SPR EA1N and EA2 PROJECTS

DEADLINE 9 – COMMENTS ON DEADLINE 8 FLOOD RISK SUBMISSIONS

Interested Party: SASES **PINS Refs:** 20024106 & 20024110

Flood Risk related responses to Deadline 8 submissions on Scottish Power Renewables proposed EA1N and EA2 onshore works near Friston

Appendix 1: Figures

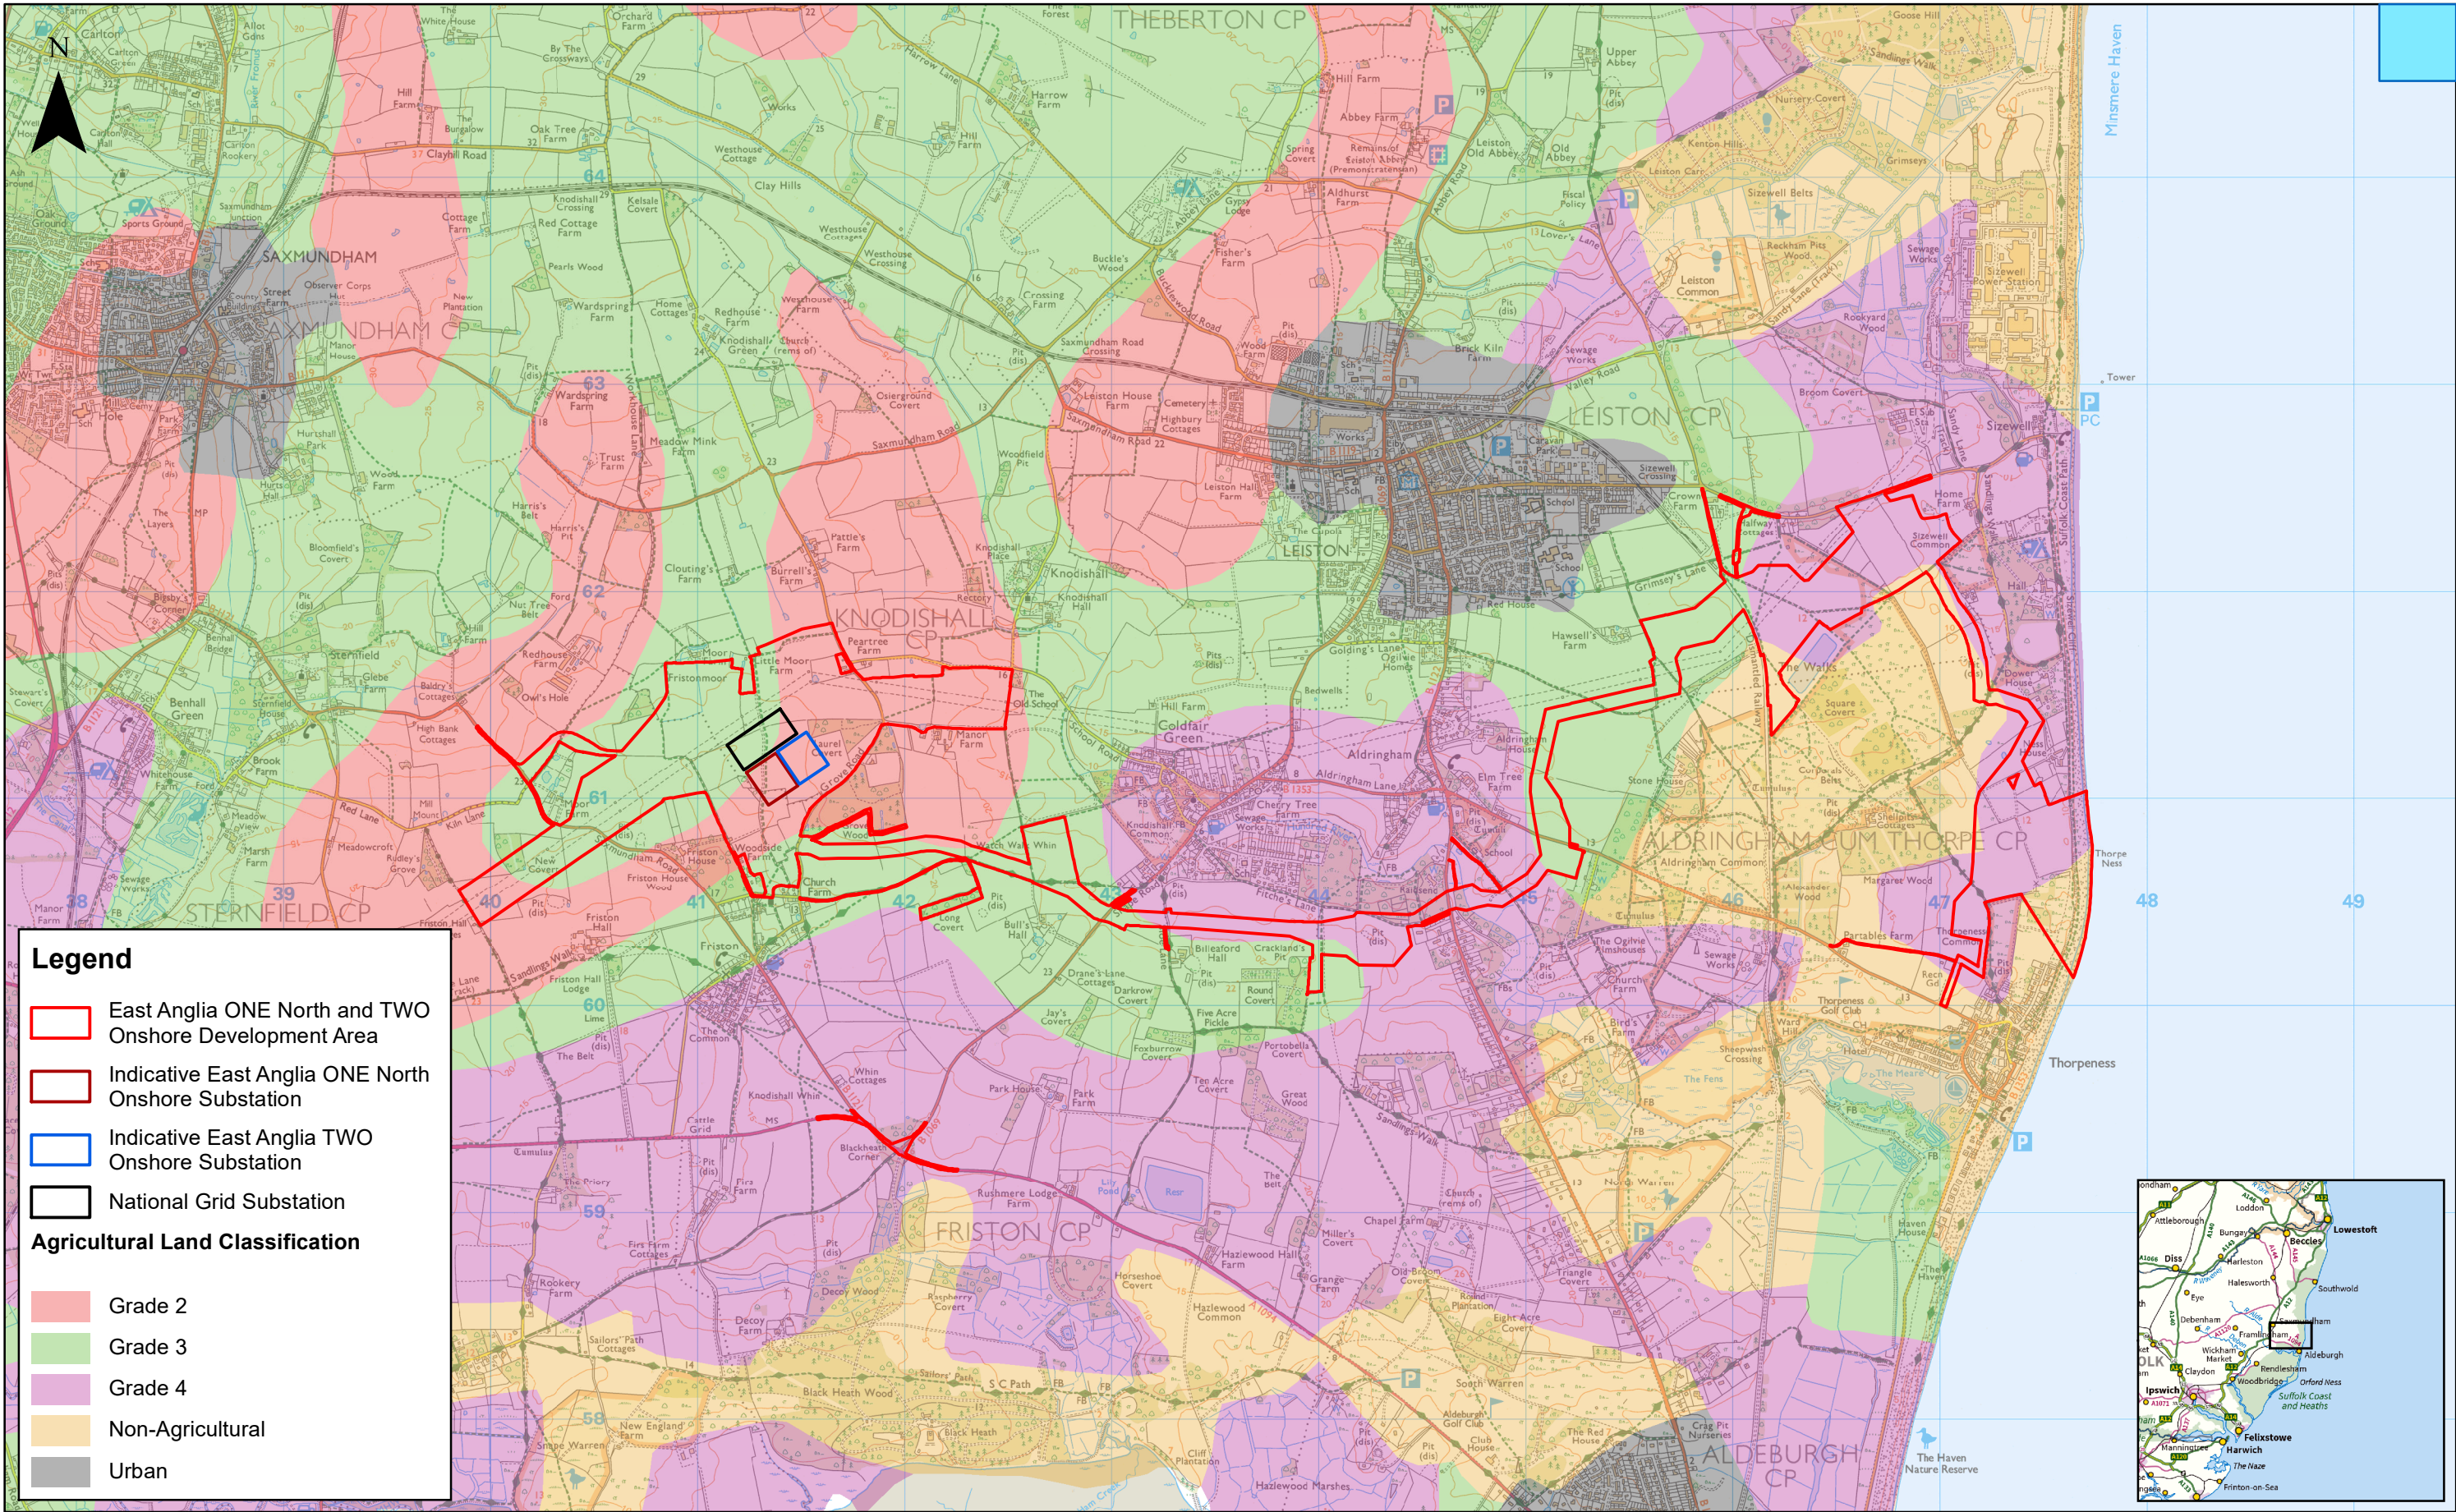
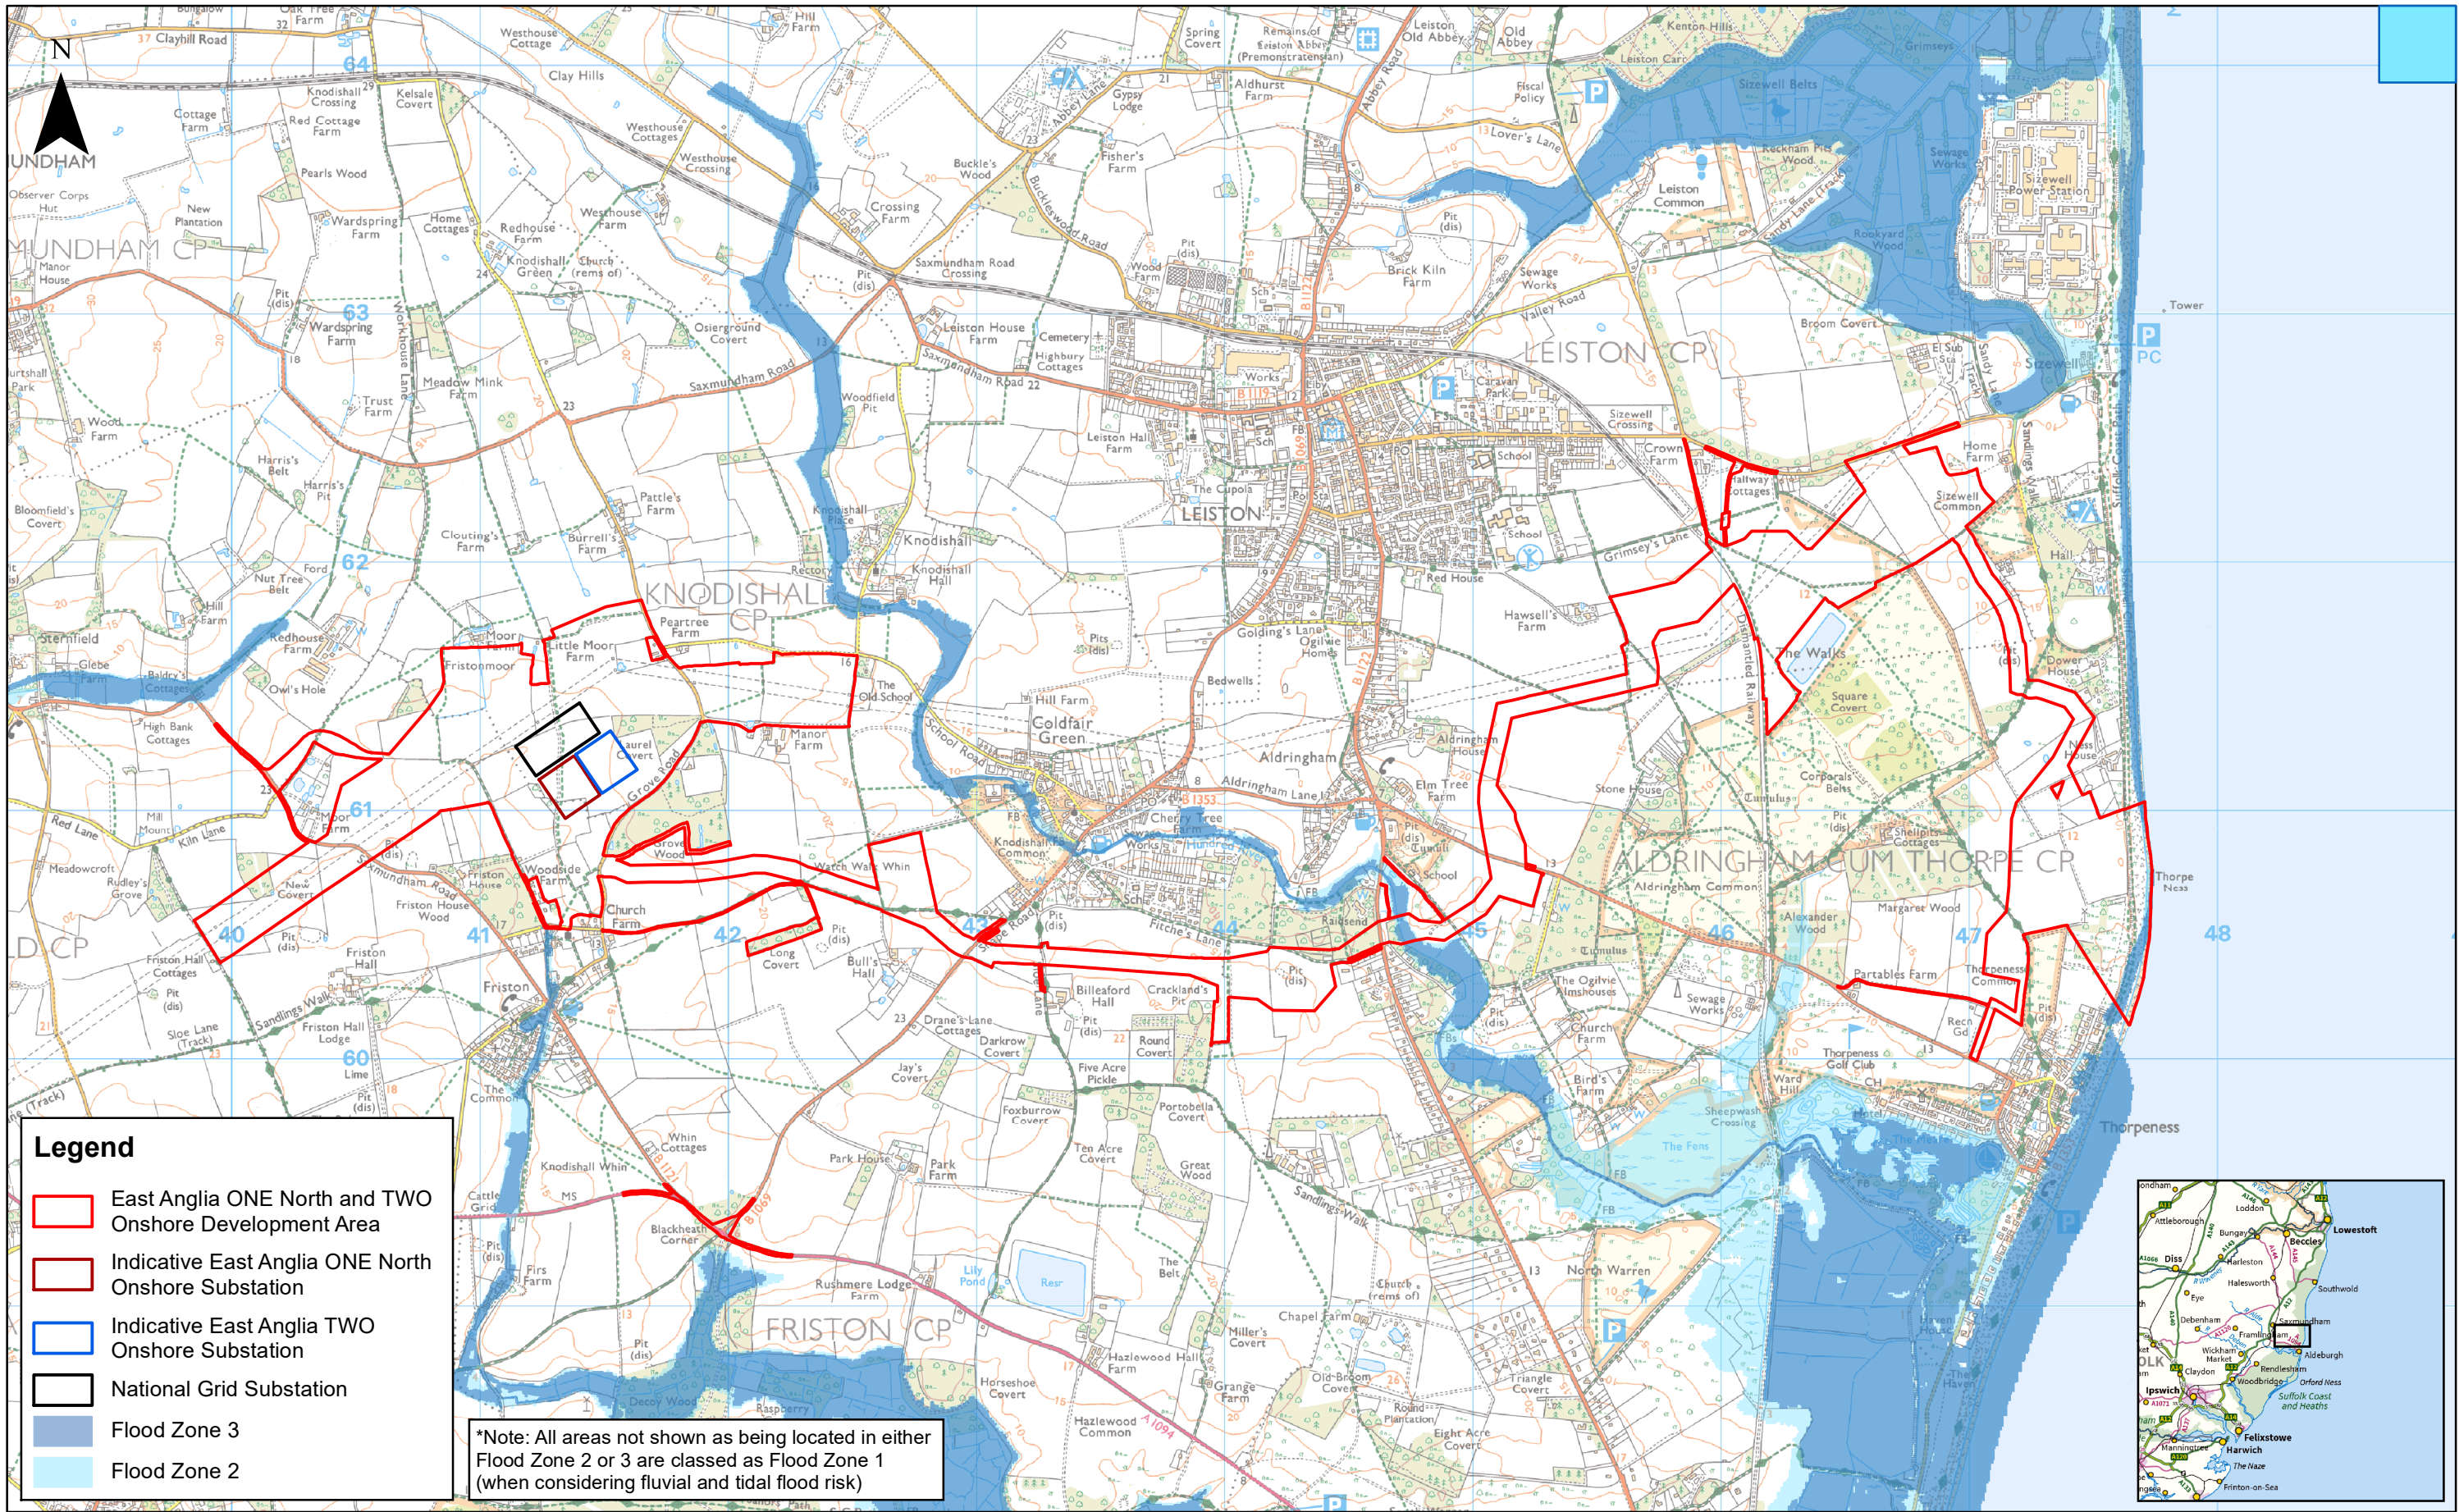
The main update to the OODMP by the Applicant is the addition of a third 'hybrid' drainage option, to the Infiltration Only option and Surface Water Discharge Only option provided before in earlier submissions. The Hybrid option is proposed by the Applicant because the Infiltration Only option cannot be demonstrated by them to be viable, and SCC refuses to accept the Surface Water Discharge Only option.

The Hybrid option (there are two hybrid basins proposed) proposes a single basin which allows water to infiltrate the ground through the base of the basin. Once the water depth in the basin reached 0.5m depth then it will start to overflow out of the basin at QBAR. Water levels in the basin will rise up to 1.5m depth.

GWP contend that whilst the Hybrid design does allow for infiltration and surface water discharge, the infiltration component is relatively minor, with effectively all water above 0.5m depth actually then flowing out of the basin to the surface water course. This design is NOT optimised to maximise infiltration, it is optimised to ensure it will fit within the site. The Applicant does not provide details of the flow hydrographs or volumes to enable comparison of the % of the flows which infiltrate into the ground compared to those which are discharged to the surface water course. It is therefore not possible to compare whether the TOTAL flow is more or less than the baseline scenario, which is a critical issue given uncertainty over both the QBAR estimate, and whether QBAR causes flooding in Friston. If the Infiltration Basin was to maximise infiltration it would be designed to fill completely and then overflow (via a controlled mechanism) to a secondary attenuation pond for discharge to surface water. This current design self-evidently stores a much greater volume of run-off above the surface water discharge outlet pipe than below it.

The proposed Hybrid design does not meet the objectives of the stated SCC SUDS hierarchy requirements nor have the design parameters been demonstrated to be accurate. The design itself therefore has not been proven to be viable.

Notwithstanding the points raised above: the proposed storage design will retain 1.5m depth of water - which breaches SCC requirements; its design volume is <2% more than the required volume – which is unacceptably small and does not allow for design parameter inaccuracy or performance inefficiencies eg blockages; and the total storage including freeboard and landscaping is with 10% of the Reservoir Act, despite being immediately above a residential village and the design is without consideration of overflow structures, which is unacceptable.

The last update to the OODMP is an outline drawing of the outfall pipe from one of the storm water attenuation basins and its discharge into the Friston watercourse. The outlet pipe is proposed to be located along the farm track and discharge into a box culvert under the road before entering the existing ditch system passing through the village.

No dimensions or design details are provided to enable estimate of cover depth or material strength, nor details of traffic or vehicle loading assessment provided, especially for the pipeline section beneath the farm track. It is not therefore possible to comment on the structural integrity of the proposed design with respect to damage from vehicle loading.

The design does however appear to have failed to consider the farm track IS the watercourse north of the road and therefore is subject to storm erosion, sedimentation and flow inundation. The box culvert into which the pipe has an open-ended outlet will therefore during operating conditions be receiving turbid run-off water from the surrounding fields and is highly likely to be both full of water constrained by the current downstream ditch geometry and routinely filled or partially filled with sediment. The outlet pipe located as it is on the floor of the box culvert is highly likely to become blocked with time and its conveyance restricted. This appears to not have been considered. Clearly the consequence of a partially or fully blocked outlet pipe is water backing up in the basins and potentially overtopping the basin bunds. The design appears highly likely to become blocked and is considered unreliable.

There are no details provided of the outfall from the second basin.
